CITY OF ALBUQUERQUE

December 23, 2021

Re: Congress Apartments
9441 Eagle Ranch Rd. NW
Traffic Circulation Layout
Architect's Stamp 09-28-21 (C13-D033)

Dear Mr. McEachern,
Based upon the information provided in your submittal received 10-25-21, the above referenced plan cannot be approved for Building Permit until the following comments are addressed:

PROJECT #2115

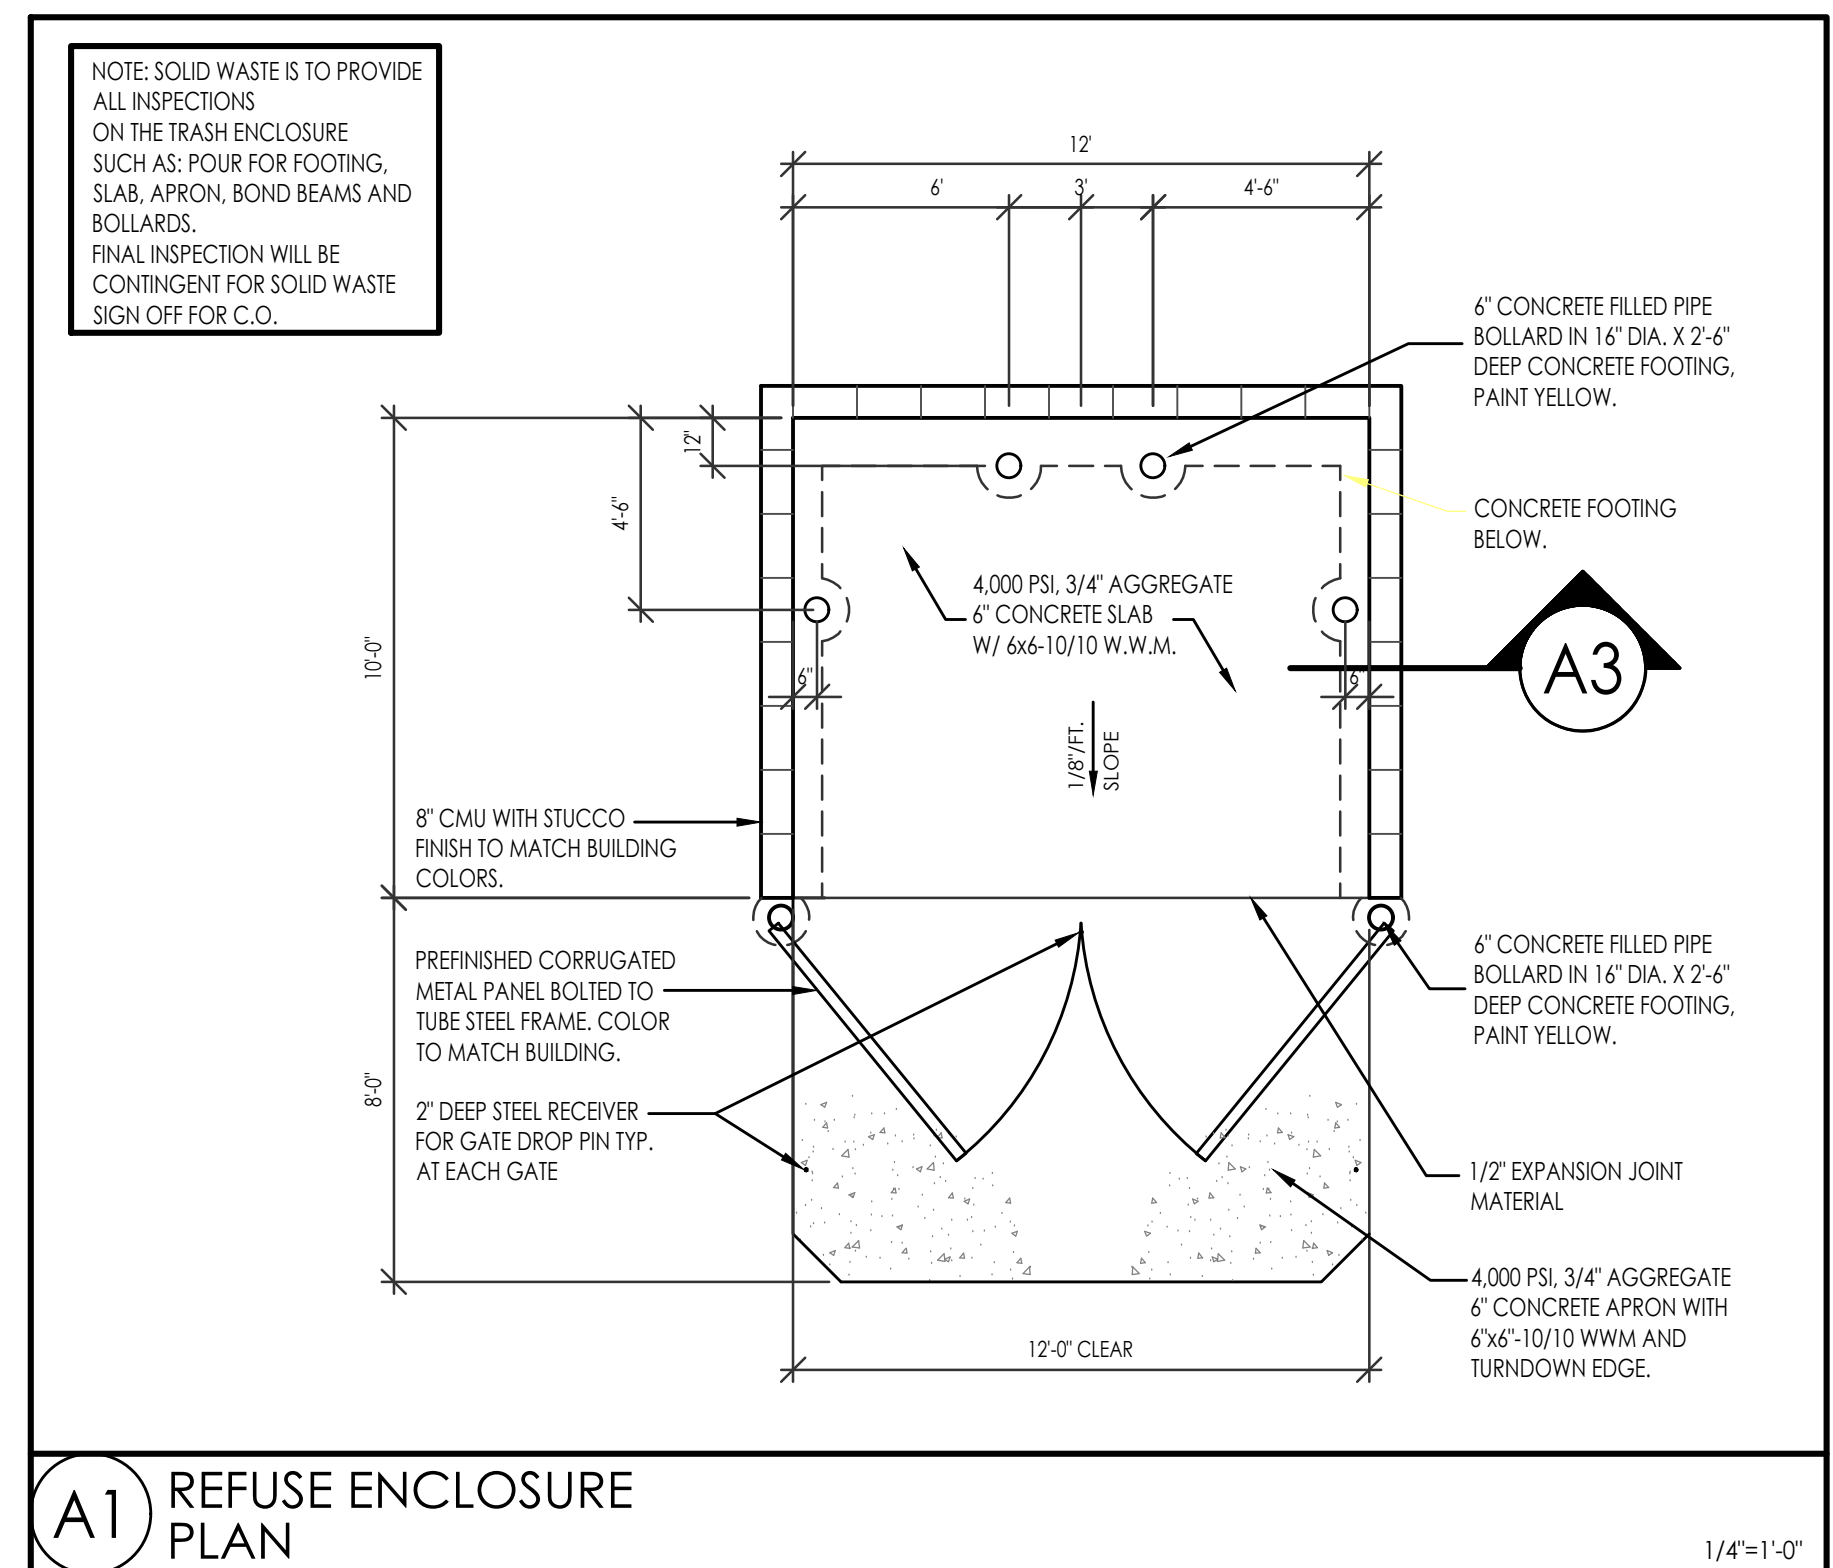
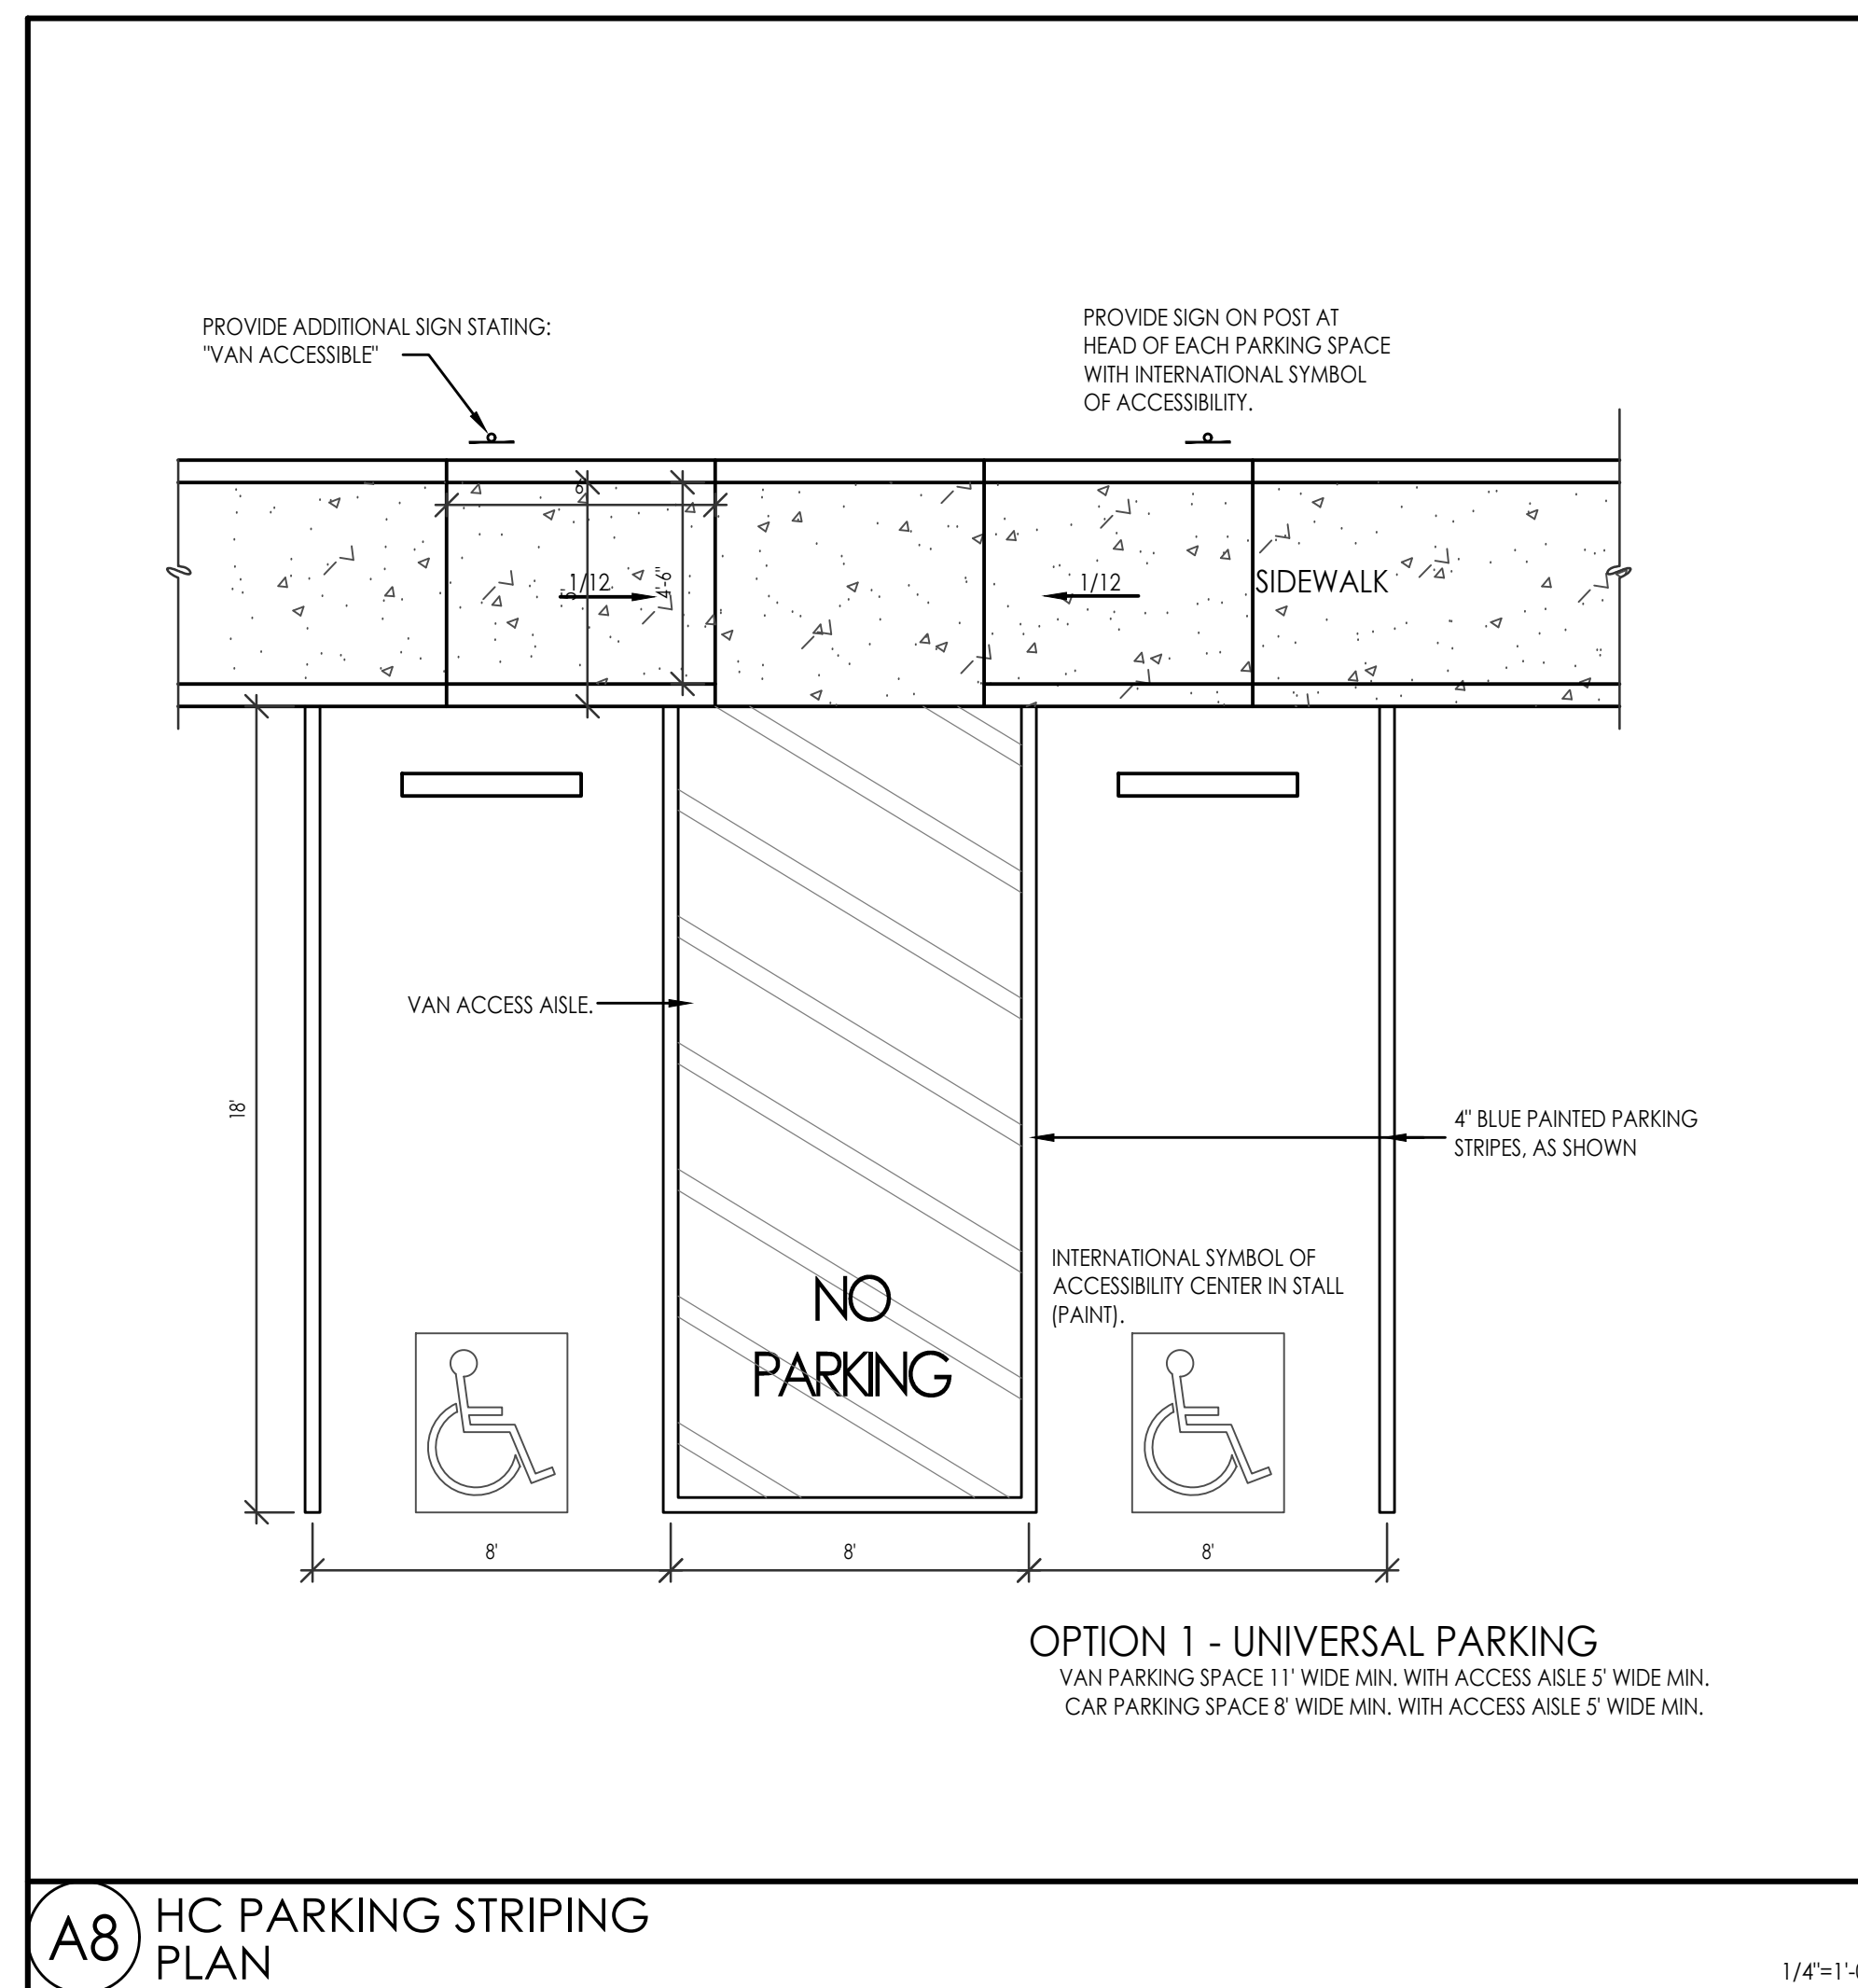
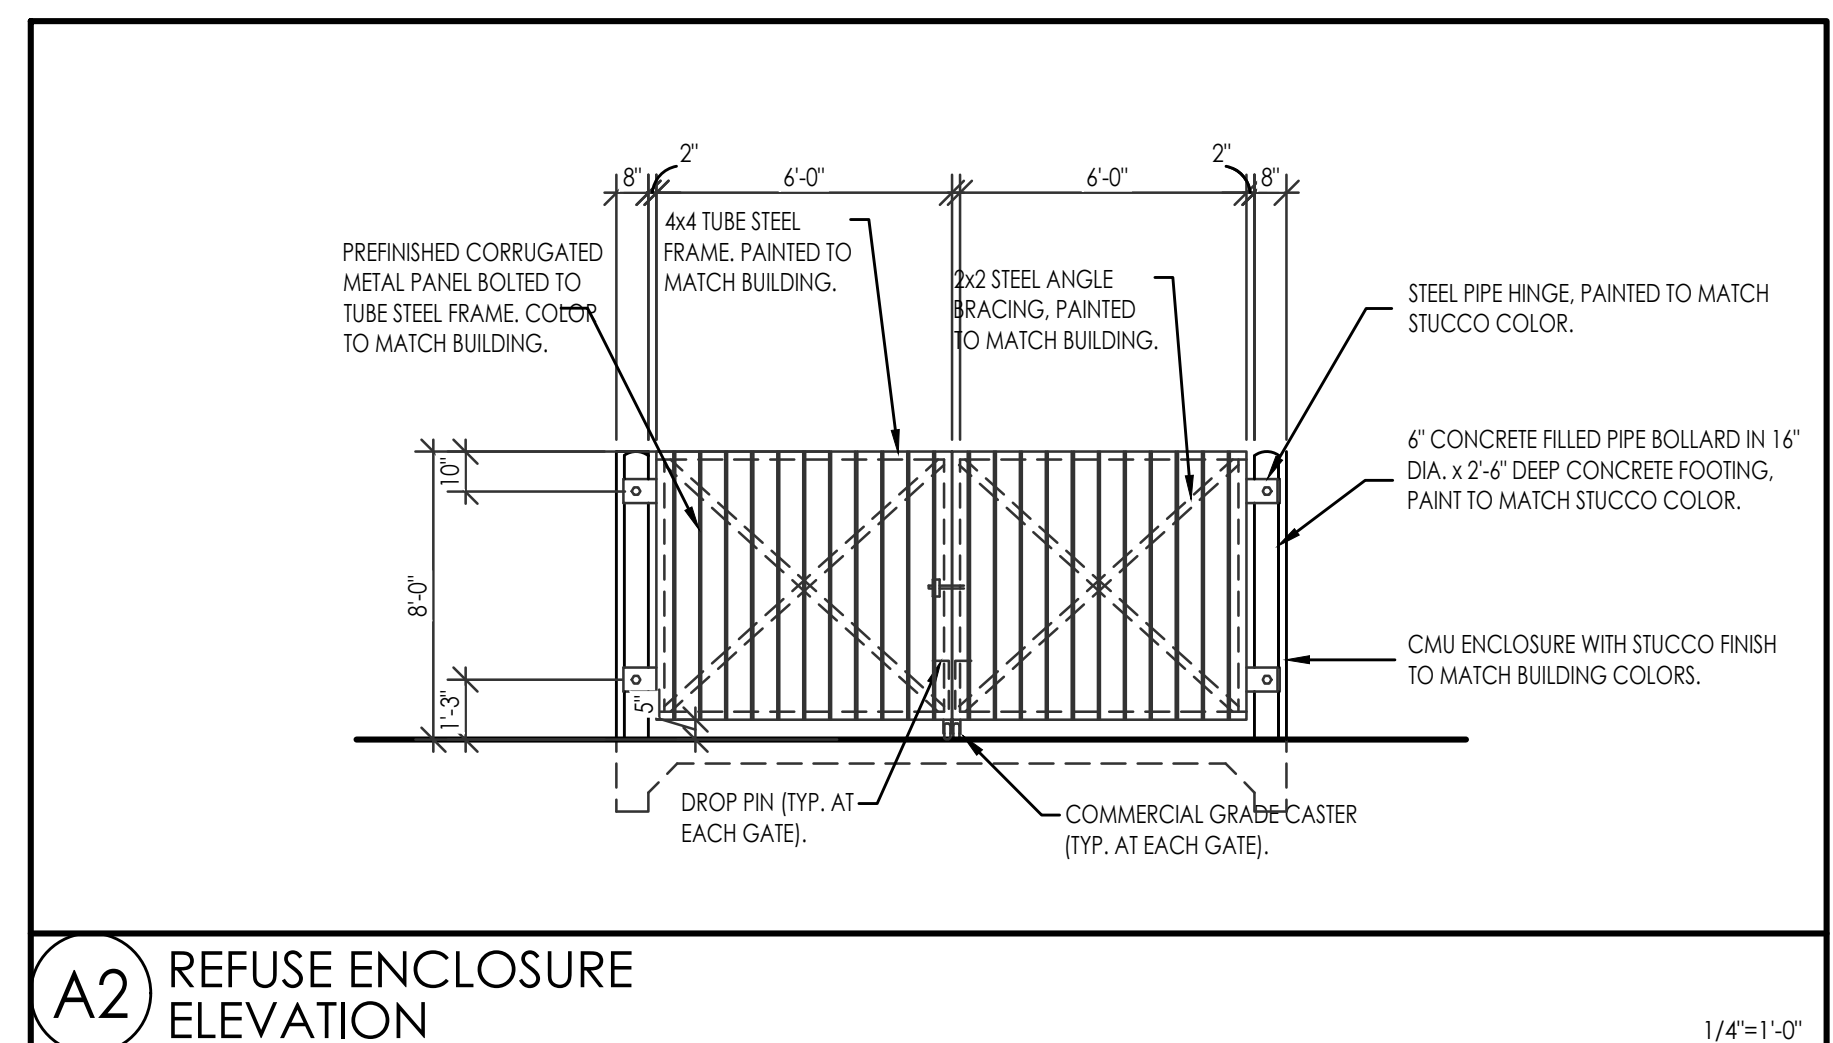
1. Provide a multi-directional ramp at the west leg of the drive entrance off Eagle Ranch Rd. where interior sidewalk connection is to be provided. Call out details.
2. Provide details for the Ramps in front of the Dumpster Enclosure.
3. Key note 20: provide dimensions for the clear sight triangle.
4. ADA aisle between building A and B should be 8.5 ft. wide.
5. The width for the Parallel Parking should minimum 7 ft.
6. Details sheet: Accessible Ramp (A10): The running slope should be 1:12 maximum. Please revise accessible ramp details.

1. Added ROW, Medians, curb cuts and street widths. See new revised AS-1.0 Site Plan sheet.
2. Added new hatch to show 6' wide ADA accessible pedestrian pathway

3. Added new 6' sidewalk at all parking stalls.
4. Removed and replaced detail A-10 on sheet AS-2.0.
5. Added detail for Handicap symbol.
6. Yes, please see detail on sheet on AS-2.0

7. Removed COA standard
8. Labeled all Fire lanes
9. See new detail A12/AS-2.0
10. Update COA standard drawings to 2426
11. Removed work order note. It was copied from a previous note.

12. Removed note. Will only remove fence on our property.
13. Removed Key note 33. It was a typo.
14. Added to key note 34 per TCL review.
15. Added ramps and COA standard drawings #2445.

16. See resubmitted Site plan.
17. The lengths were on the plan in the Curve Table at the top of the page, added the lengths to the plans at per TCL review.

18. Added dimensions to curb cuts.
19. Added new ramp details on sheet AS-2.0 and note to keynotes to reflect detail.
20. Please see attached email between owner and adjacent owner.

21. Added curb barrier to parking spaces as needed.
22. Extended Island ramp, see revised site plan
23. Add note for all bollards to be painted yellow/
24. Updated detail to reflect TCL Review.
